**Application by Mallard Pass Solar Farm Limited for an Order Granting Development Consent
for the Mallard Pass Solar Project – project ref. EN010127**

Submission by Mallard Pass Action Group (MPAG) – unique ID ref. 20036230

Deadline 1: Comments on Relevant Representations (RR)

#### Insert 12.1: Explanation of Area Measurements

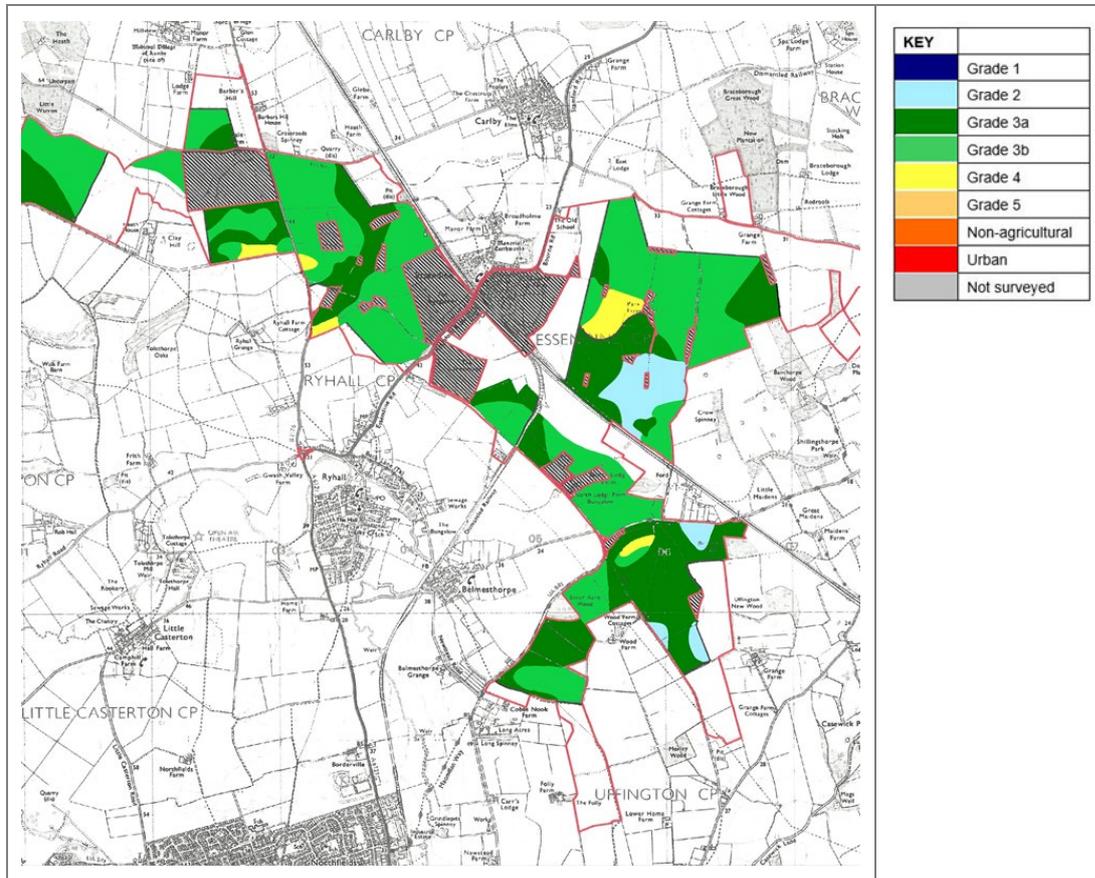
MPAG fully support the NE’s request for a clearer breakdown of the BMV land as outlined below. The current level of detail on BMV breakdowns is inadequate especially when you consider the significance of 360Ha of land being affected on the site. They also draw attention to the significance of assessment needing to take account of the pattern of grades, so that the highest significance value for the agricultural land receptor is that which is then applied to the site as a whole.

“An assessment of potential impacts of the Mitigation and Enhancement area on agricultural land and soils has not been undertaken by the Applicant. The ES (Chapter 12) should include either an additional table or an expanded table 12.1 to clearly show the amounts and proportions of agricultural land, including BMV across the full Order Limits, impacted by each element of the Proposed Development, including permanent infrastructure, temporary solar PV arrays; retained arable fields and other mitigation and enhancement options.”
